The Five Village Society

11th December 2014

Y/93/14/OUT - Land north of Yapton C of E School - 40 units

DRAWING NO YAP/DR/1

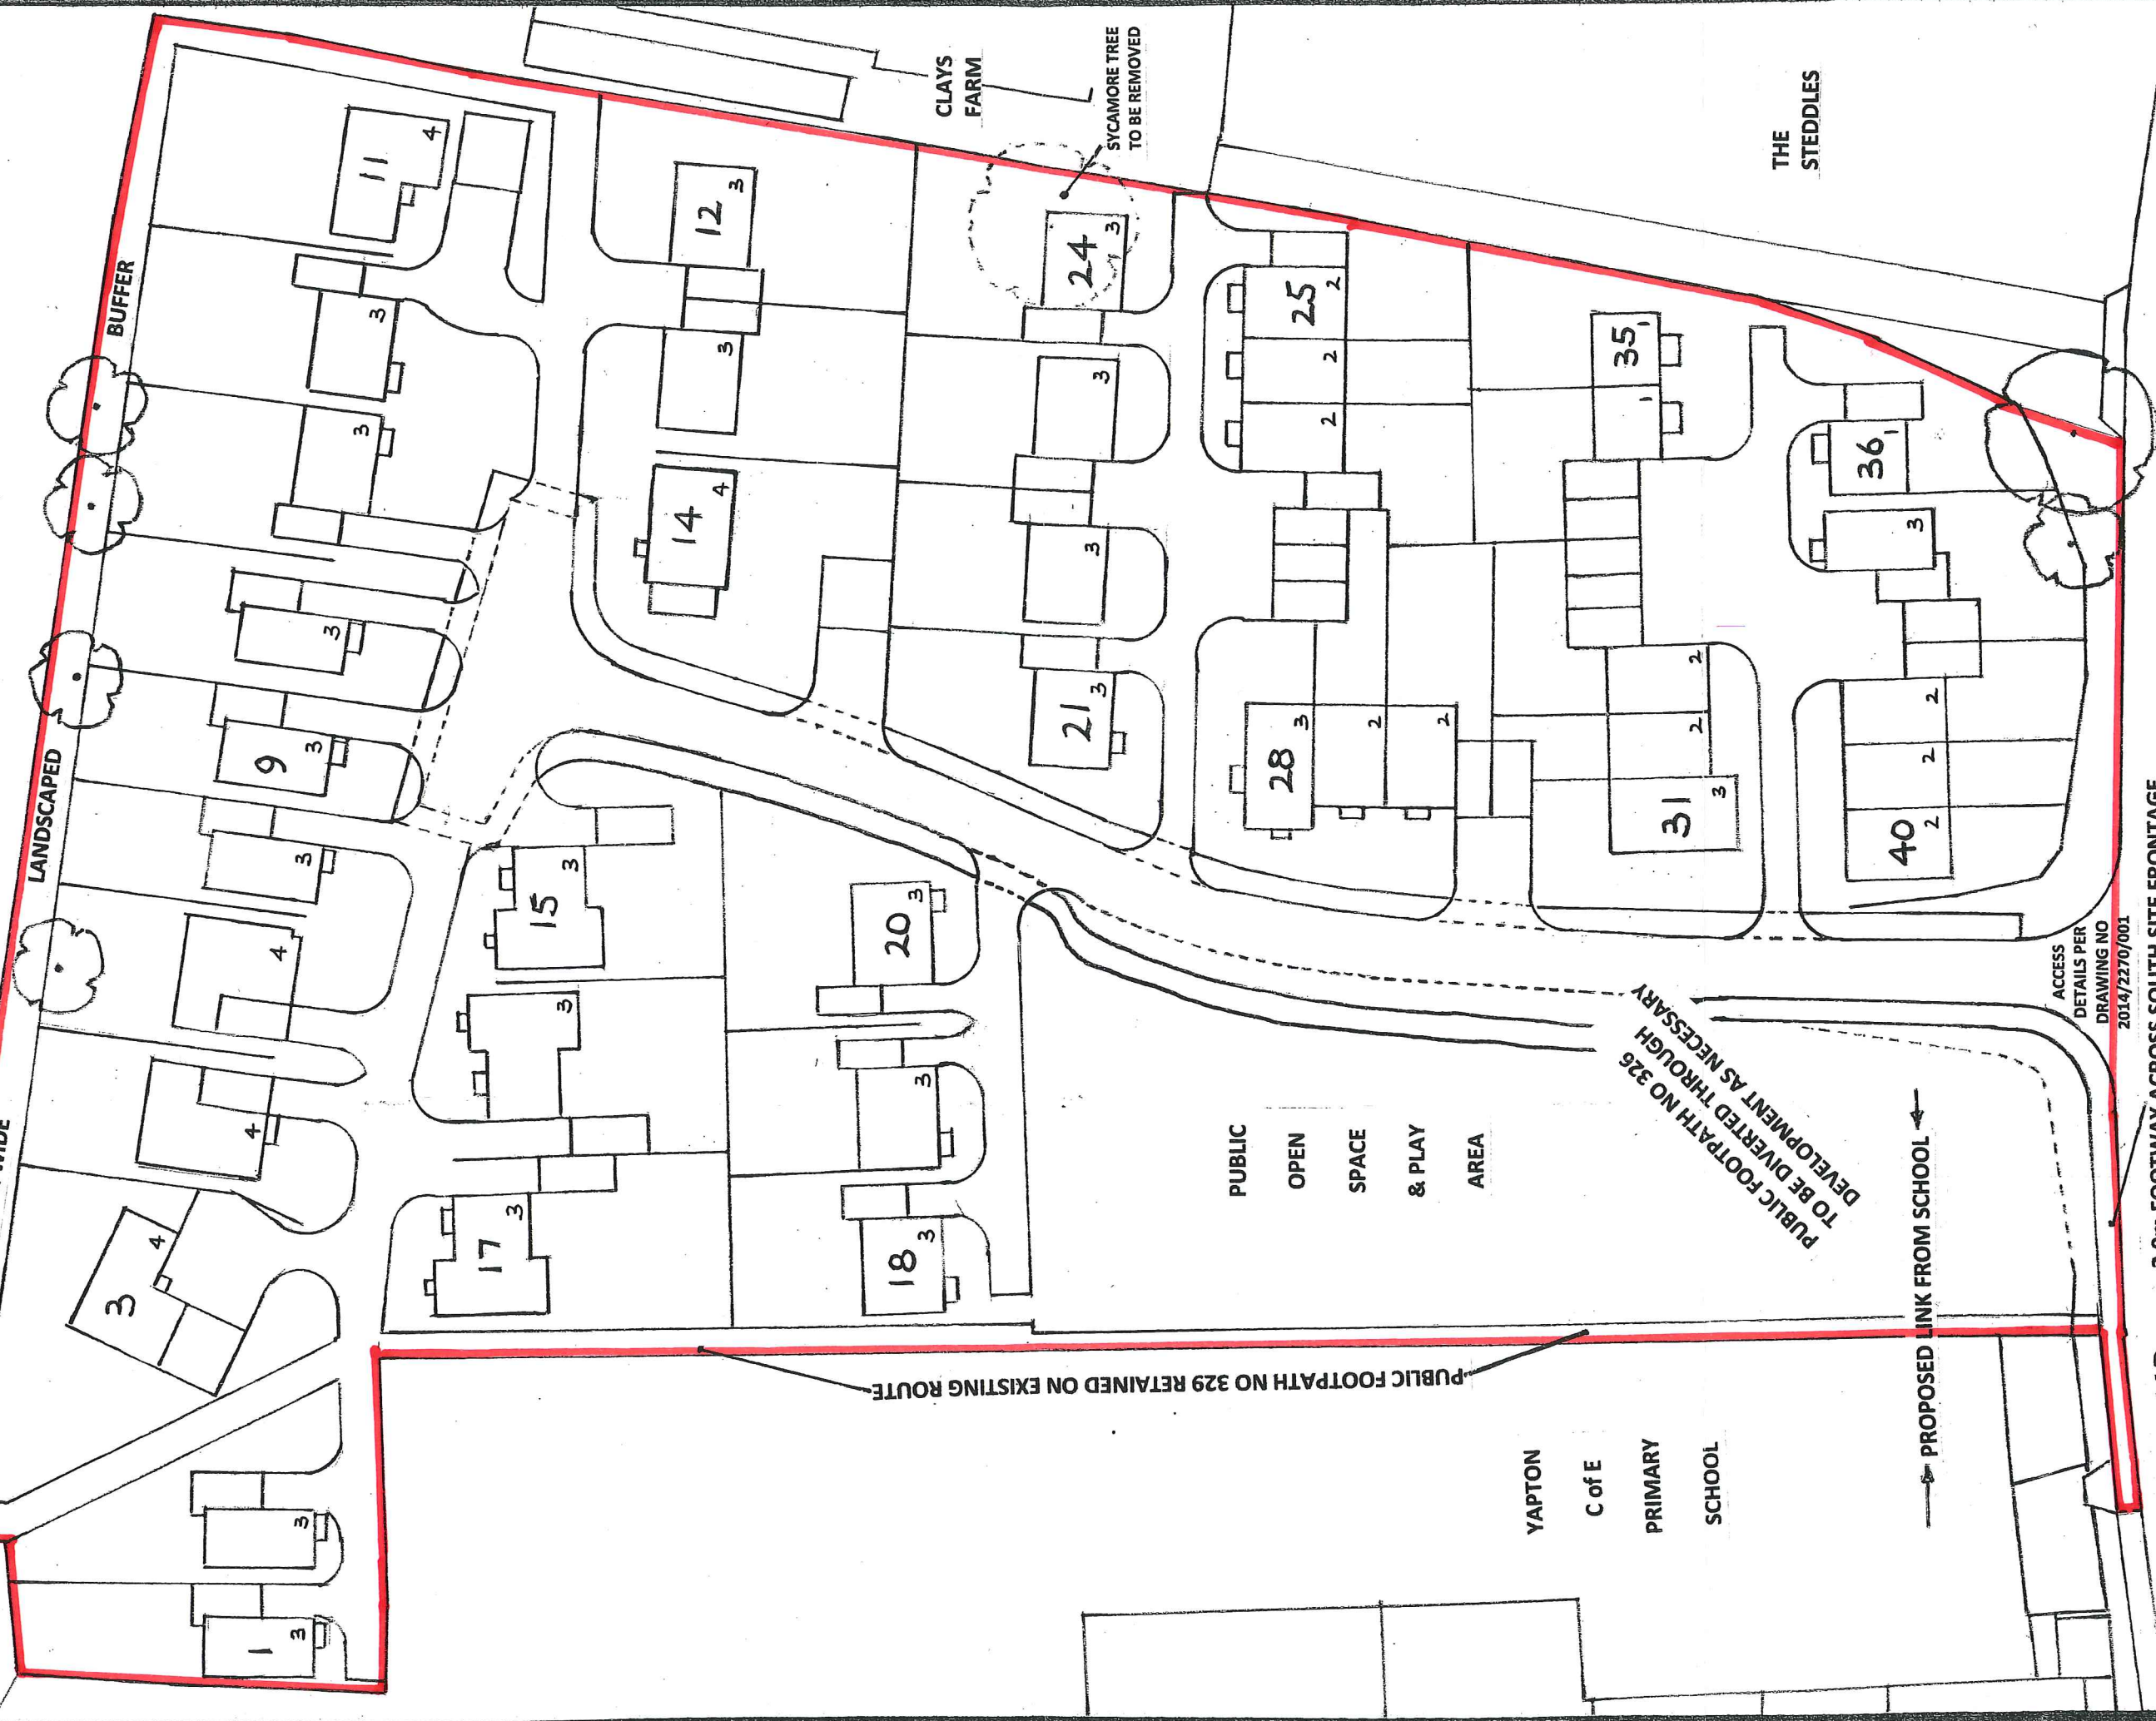
- 1) The site is in a rural setting of agricultural land on the northern edge of the village settlement. It is next to the primary school with over 300 pupils.
- 2) 40 units will be an overdevelopment of the site. The tight layout and repetitive design does not reflect the style and character of surrounding individual properties.
- 3) The approved Yapton Neighbourhood Plan proposes a lower density for the site.
- 4) A courtyard layout would be more appropriate.
- 5) Access to the site opposite the junction with Church Lane and Orchard Business Park and will cause hazards.
- 6) The school traffic causes major congestion, especially from parked cars.
- 7) No footpath on the west side of North End Road.
- 8) Inadequate parking spaces provided for visitors and each household.
- 9) No landscaping shown for the site.
